re: **Geotechnical Design Summary Details**
Metric Homes – Block 123
950 Terry Fox Drive – Ottawa

date: March 5, 2026

file: PG2855-MEMO.76 Revision 1

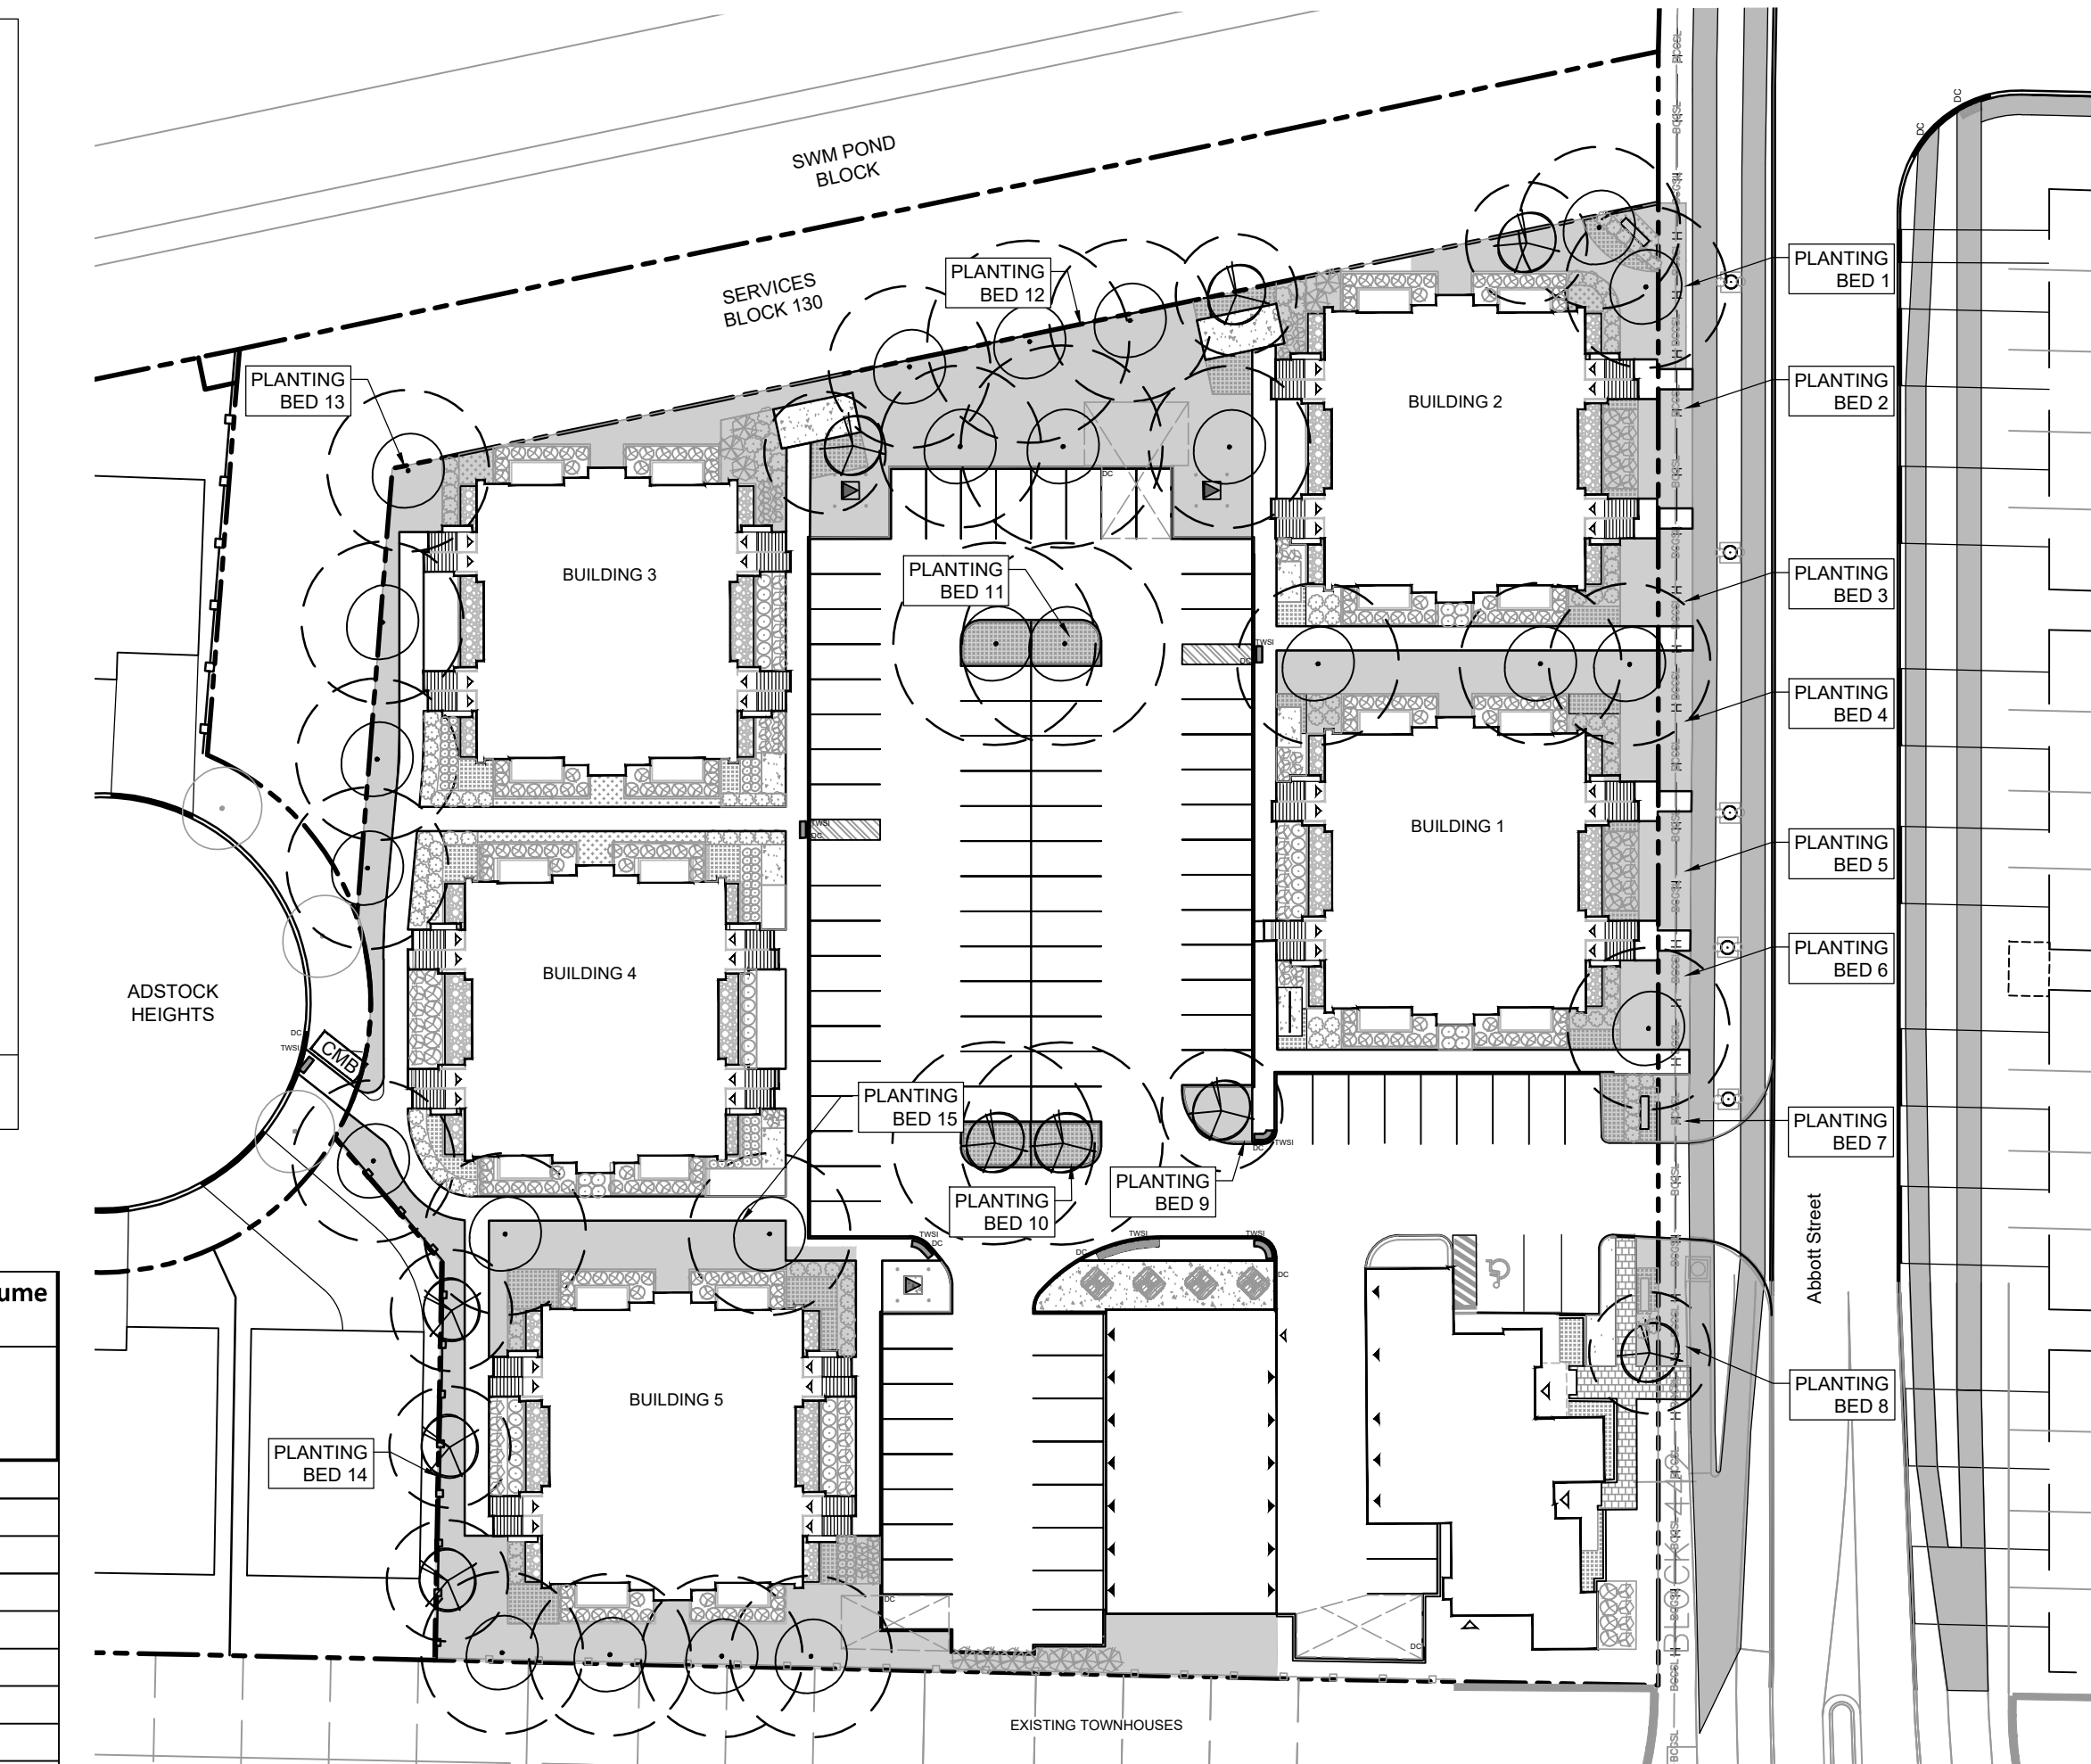
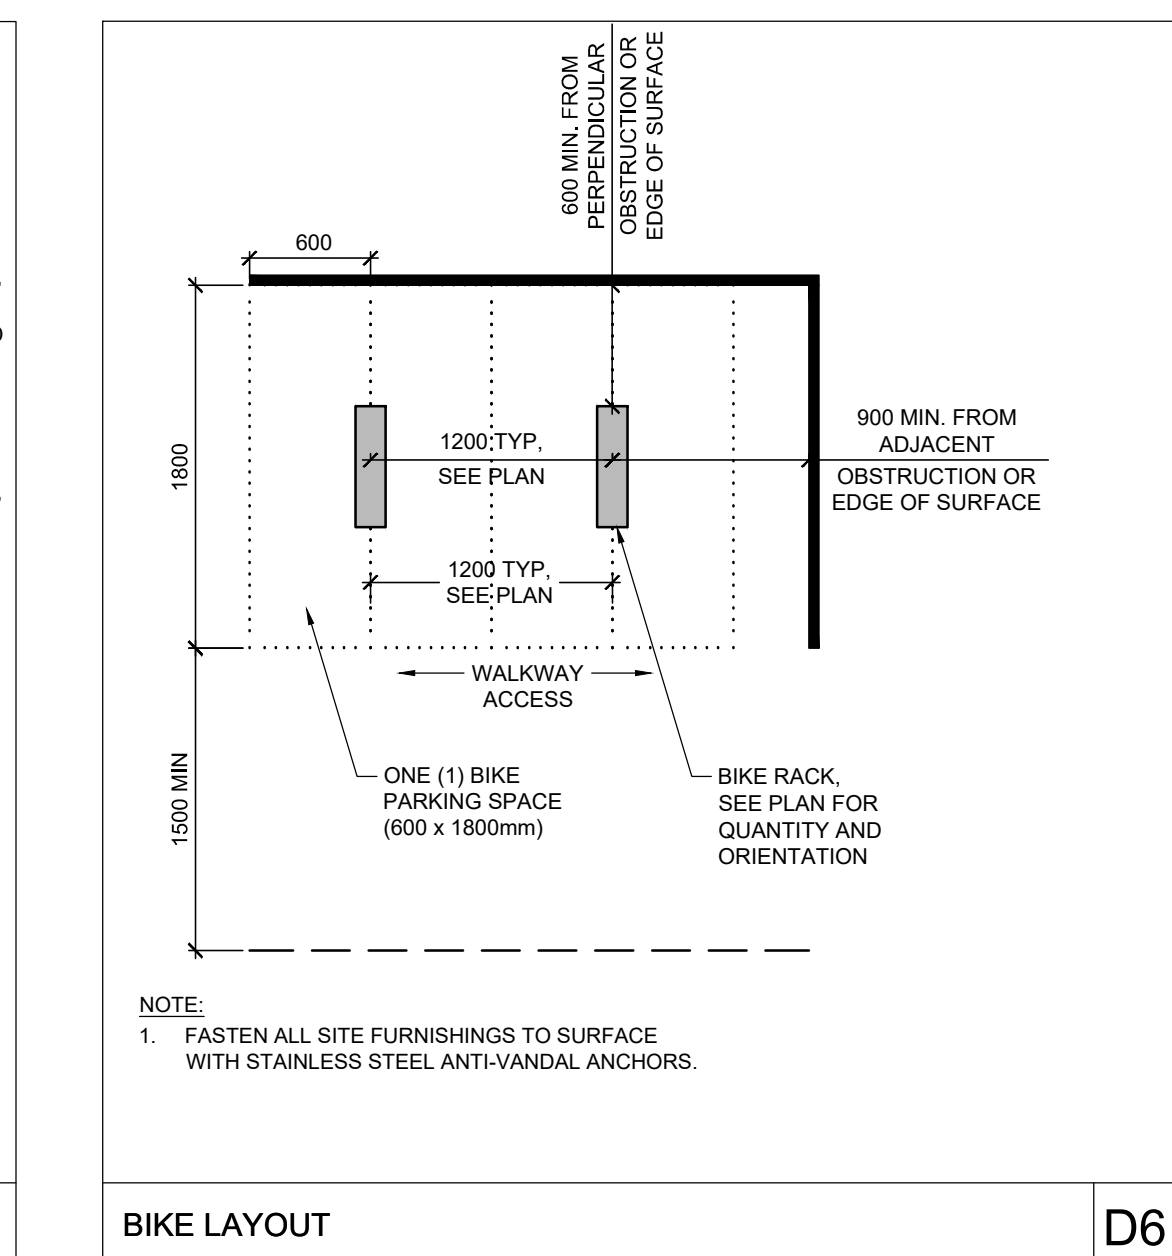
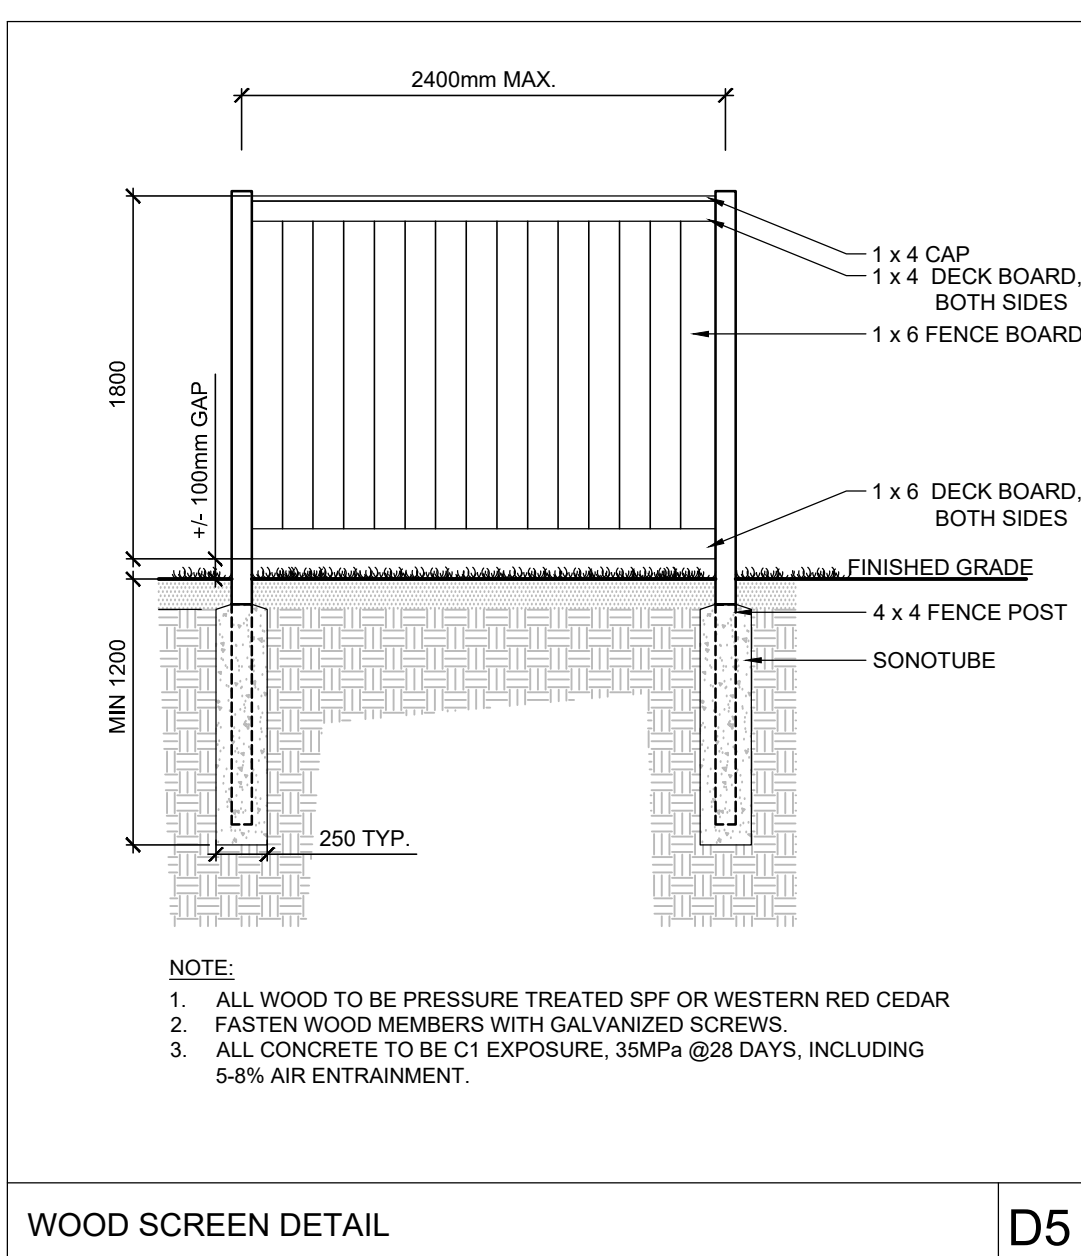
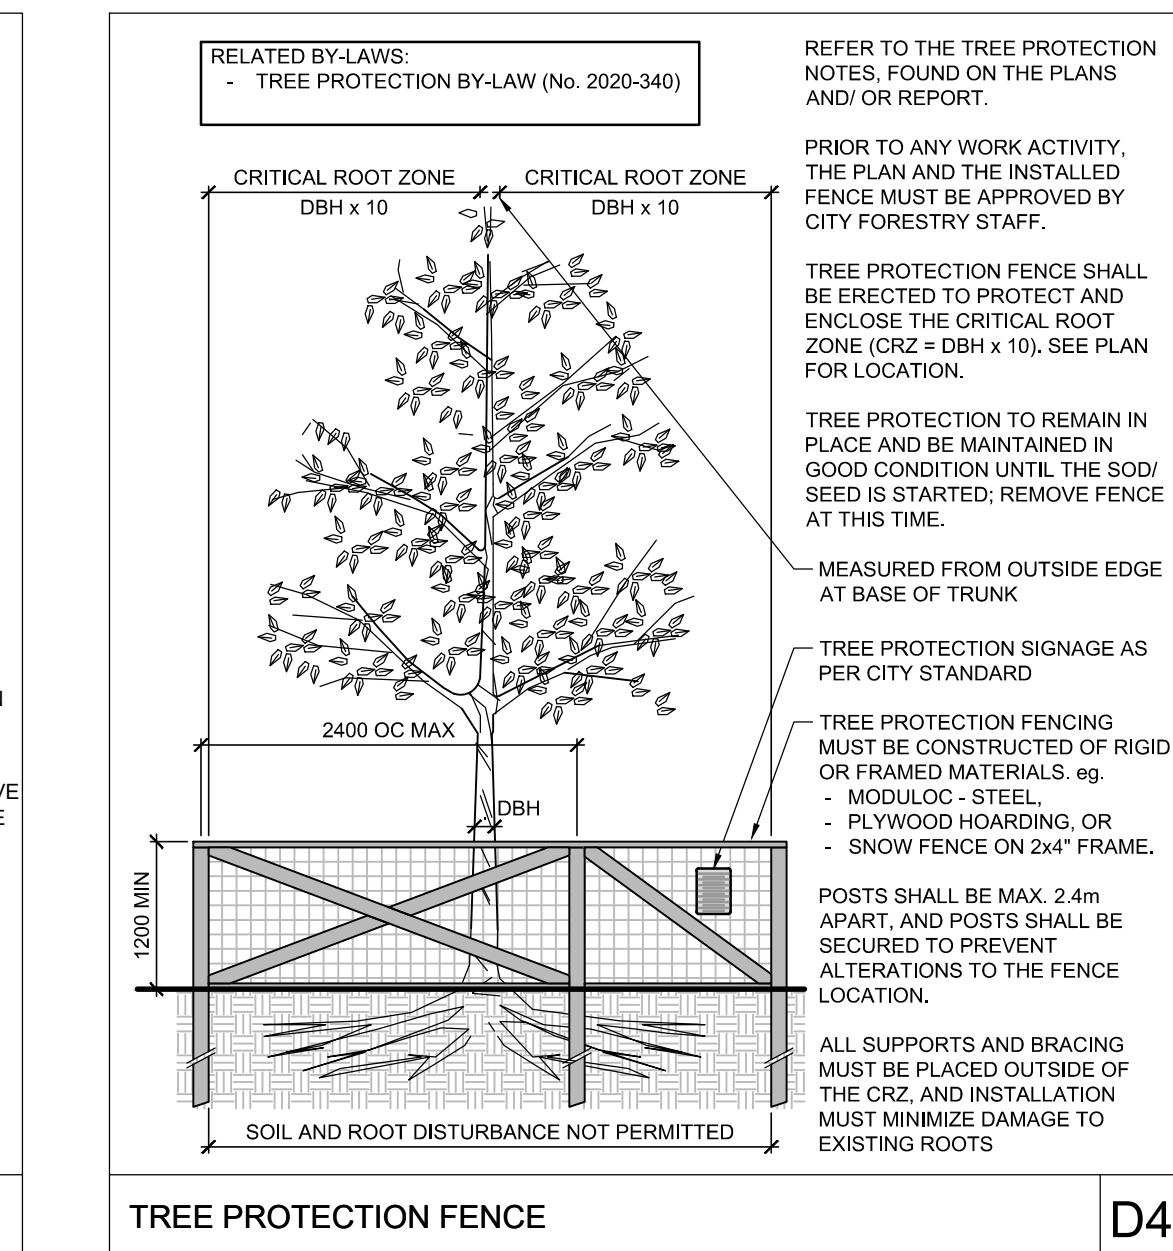
- ❑ Landscape Plan and Tree Conservation Plan – Block 123, 4829 Abbott Street East, Kanata — Drawing No. 110037-B123-L1 – Project No. 110037 – Revision 5 dated February 12, 2026.

Based on the above-noted drawing, a minimum setback of 4.5 m from the nearest building foundation is provided for all proposed small and medium trees at the subject site. Furthermore, a setback equal to, or greater than, the mature tree height is provided for all proposed large trees at the subject site.
